One Earth Solar Farm

**Draft Statement of Common Ground with Nottinghamshire
County Council**

EN010159/APP/8.3.1

August 2025

Document Reference: EN010159/APP/6.20.1

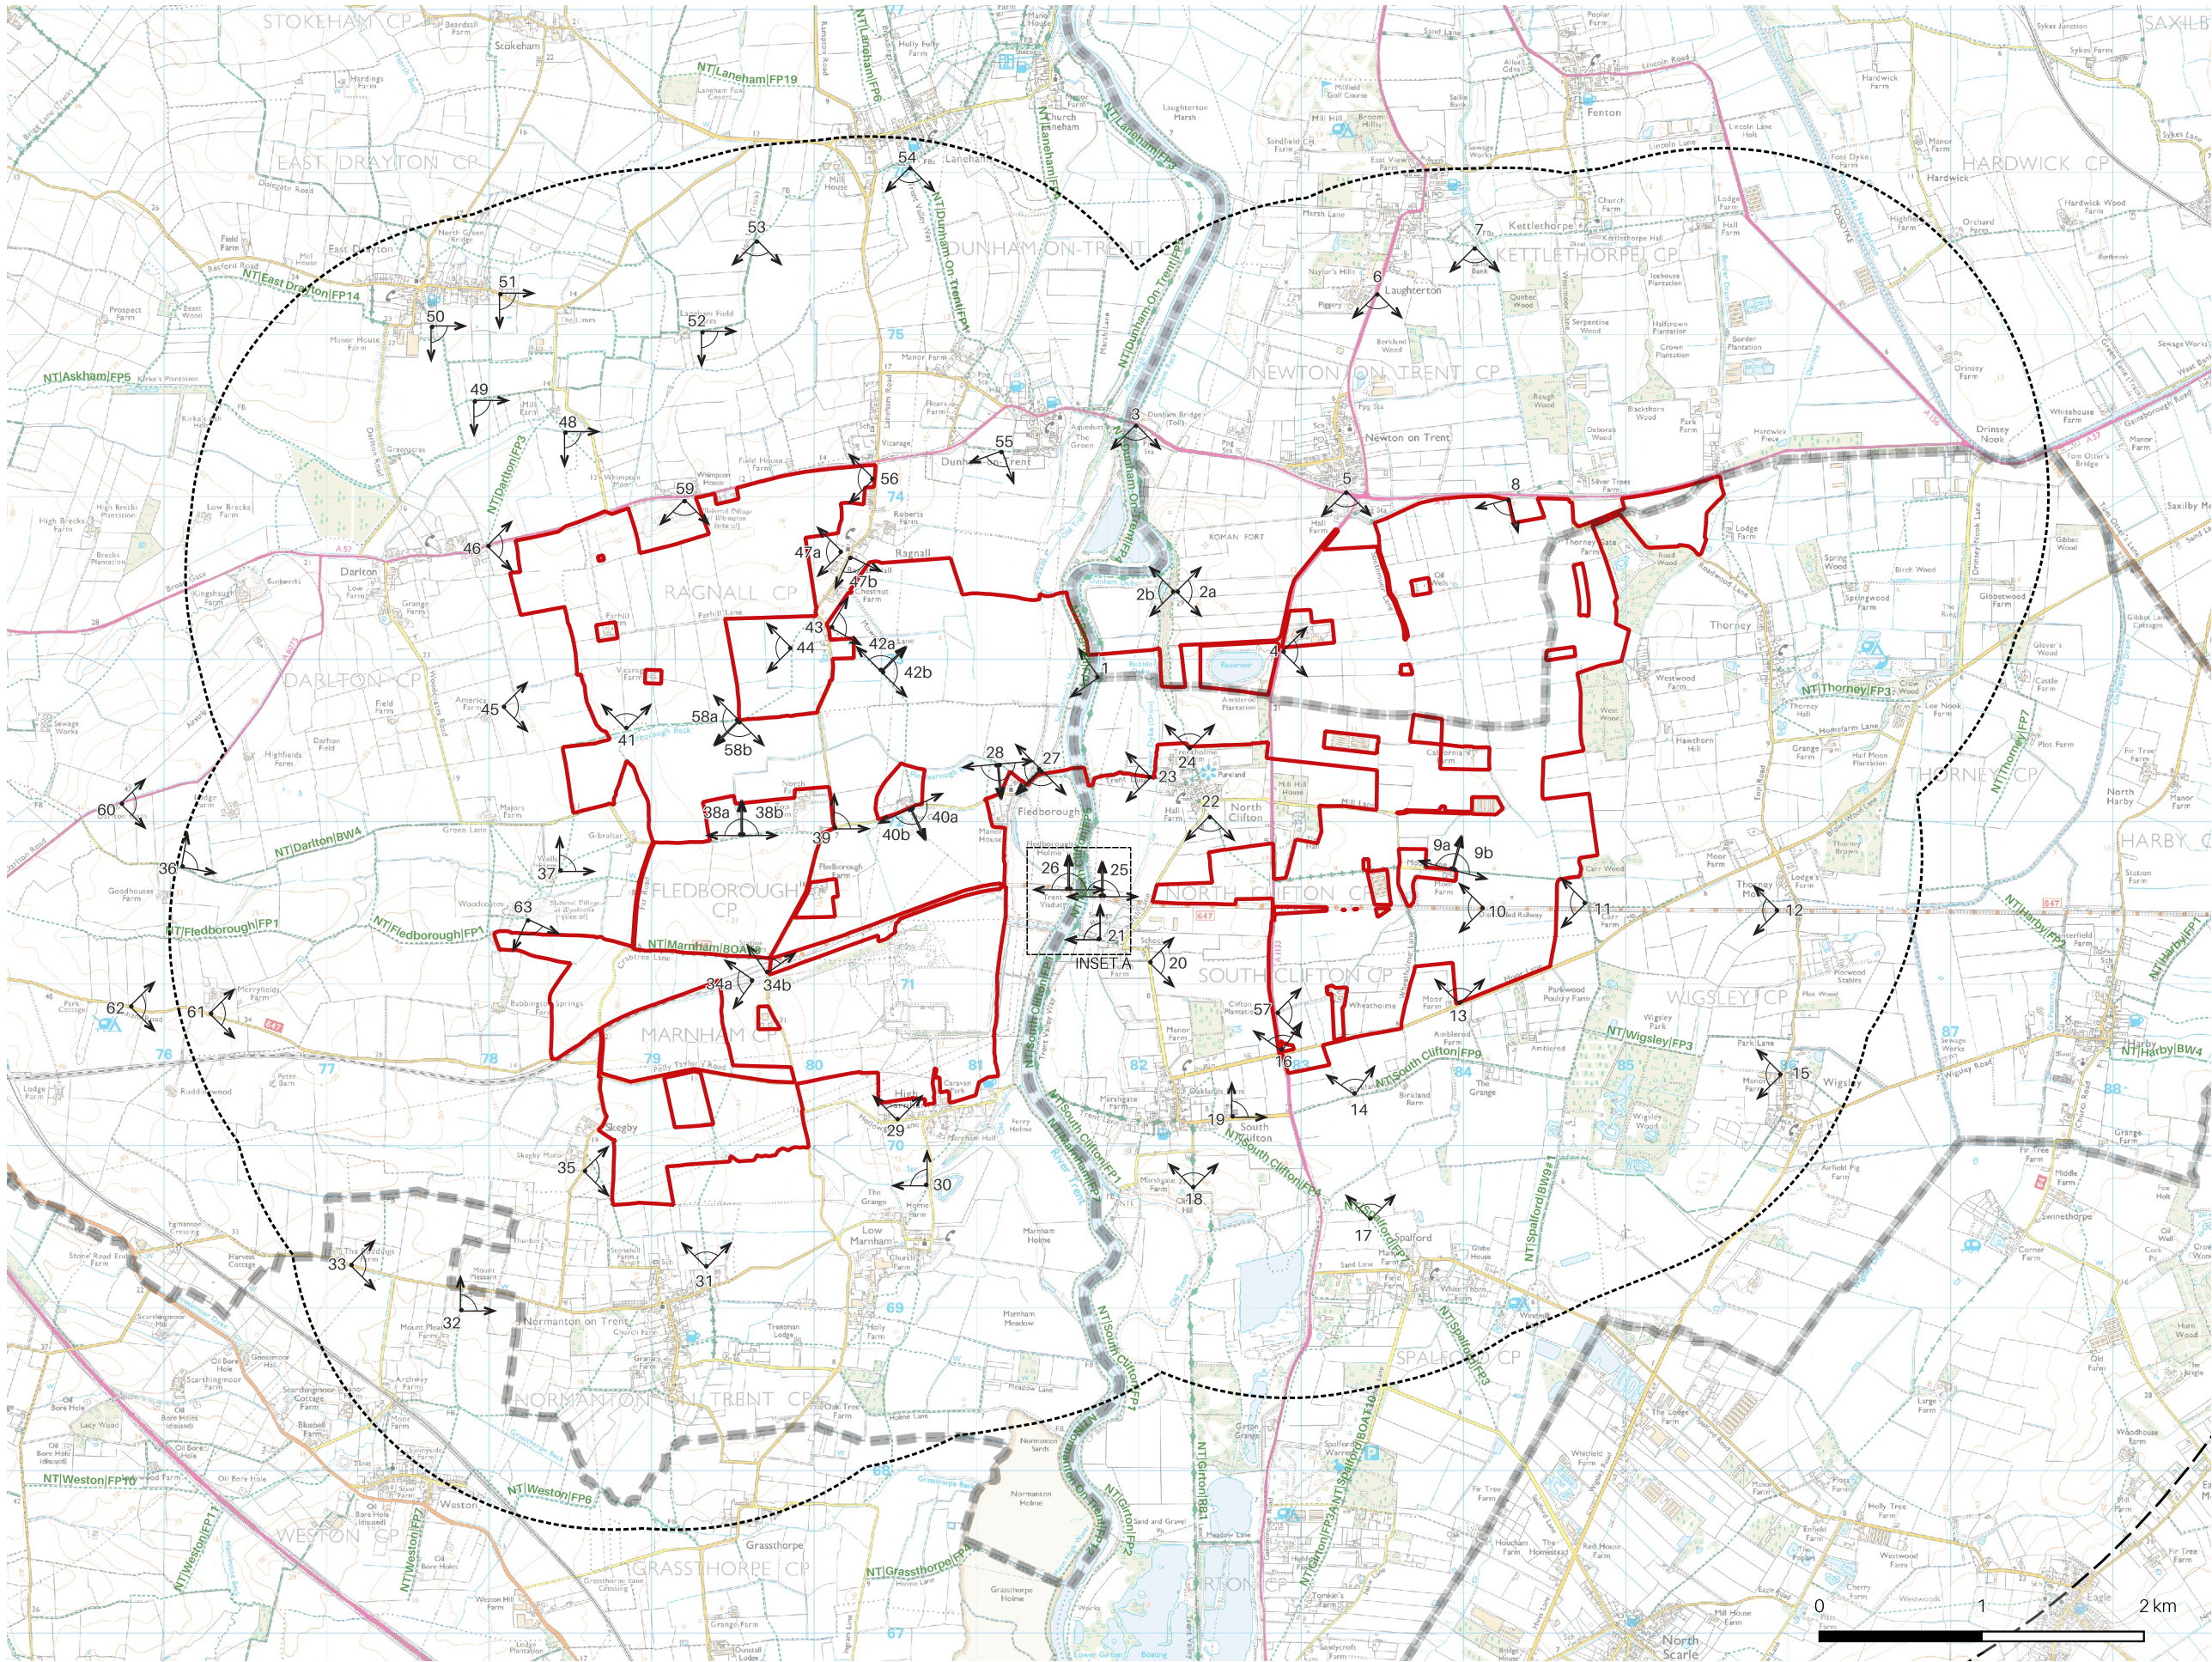
05-05	Scope of representative viewpoints	The location of some of the representative viewpoints were questioned and additional viewpoints were suggested following review of the PEIR. No further comments or concerns on the scope of representative viewpoints have been raised.	The scope of representative viewpoints is agreed. The scope of representative viewpoints was updated in the LVIA ES Chapter to include for the suggested additions and refinements.	Agreed
05-06	Scope of photomontages	An additional Type 4 photomontage was suggested from Viewpoint 58 following review of the PEIR. No further comments or concerns on the scope of representative viewpoints have been raised.	The scope of photomontages is agreed. Further discussion was had between the applicant and the District Councils during the preparation of the LVIA ES Chapter regarding the scope of photomontages	Agreed

resulting in agreement that the number and distribution of locations is sufficient.	
05-07	Assessment assumptions and limitations	The approach to solar panel replacement during the operation phase was questioned following review of the PEIR. No further comments or concerns on the assumptions and limitations have been raised.	The assumptions and limitations of the LVIA are agreed. Additional detail was provided in the LVIA ES Chapter to include a reasonable worst-case scenario with regard to solar panel replacement during the year 15 operational assessment scenario.	Agreed
05-08	Level of effect on landscape receptors	The number of significant adverse effects identified in the applicant's assessment was noted as being of initial concern, but more detailed evaluation will be included in the Local Impact Report. The LIR clarifies that several landscape character areas that will have direct effects of development at all phases have not been judged to have Significant residual effects. This appears inconsistent with the findings of effects to the Order Limits and landscape character areas of TW PZ 20 and MNF PZ 09; AAH Consultants would judge that all landscape character areas directly affected by the Development would have residual Significant effects – primarily through a change of land-use. This needs to be clarified.	A productive meeting was held between the applicant and AAH consultants on 25 th June 2025 whereby some level of effects on some landscape receptors were discussed. It was agreed that the applicant will await further clarity from the Council's Local Impact Report before discussing further.	Under discussion
